City of Albuquerque Stormwater Construction Site Inspection Report

ESC File No.	K14E017	Project Name:	Legacy Central and Broadway Hotel		
NPDES Id. No.	NMR1001MD	Location:	SW Corner of Central and Broadway		
7/8/2021	Owner	Contractor			
Operator	Legacy Hospitality	Kassam Construction, LLC			
Contact name & title	Faisel Kassam	Matt Ferreira			
e-mail	fkassam@legacy-hospitality.com	mferreira@kassamconstruction.com			
Contact Phone #	505-243-6000	505-415-4568			
COA Inspector	Thomas Evans	Start/End Time:	11:05 AM-11:30 AM		
Construction Phase:	Building construction, flatwork				
Type of Inspection:	☒ Regular	☐ Storm Event	☐ Past Storm Event >0.25"	☐ 311/Complaint	☐ Follow Up
Weather at time of inspection?	clear	Temperature:	~	85	
Estimated date of last storm 0.25" or greater	7/6/2021

Concrete Washout Area

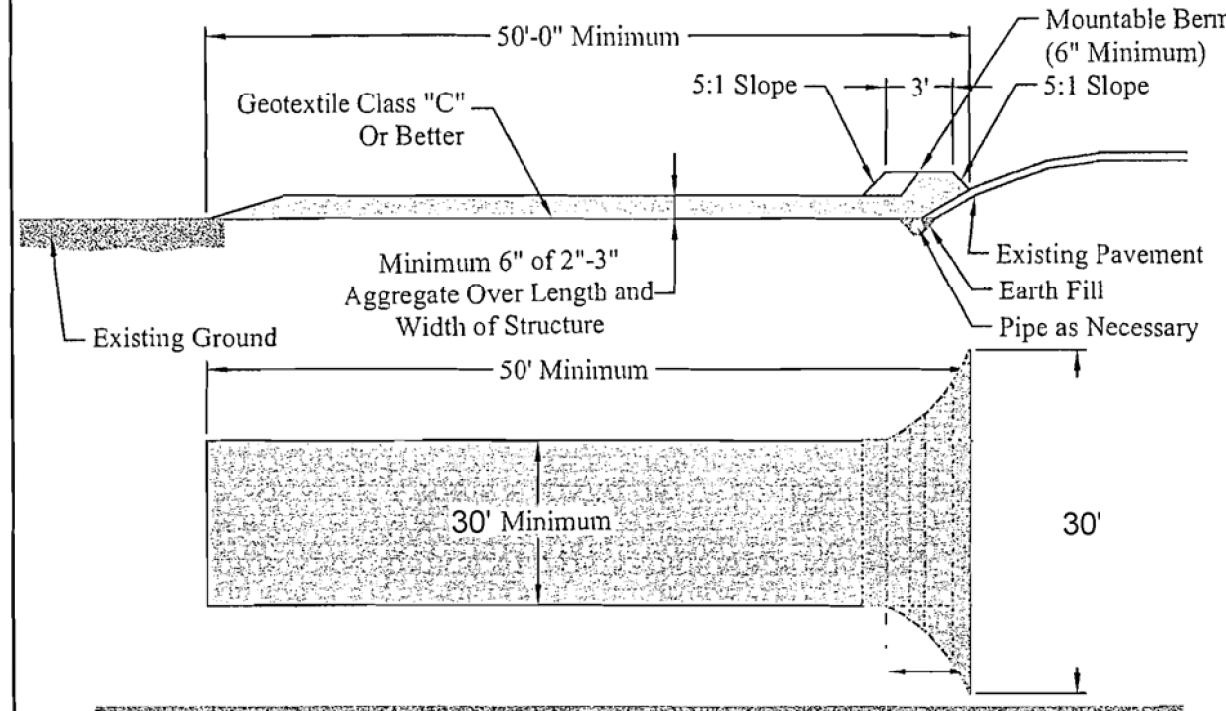
Item Number	Deficiency/ Corrective Action				
1	Sediment in west channel. Remove accumulated sediment daily from the channel on the West side of the site and from the streets.				
2	Washout on the ground. Direct washwater into a leak-proof container and dispose of properly in a an approved waste container.				
3	Self-inspection reports not in the SWPPP and not provided upon last request.
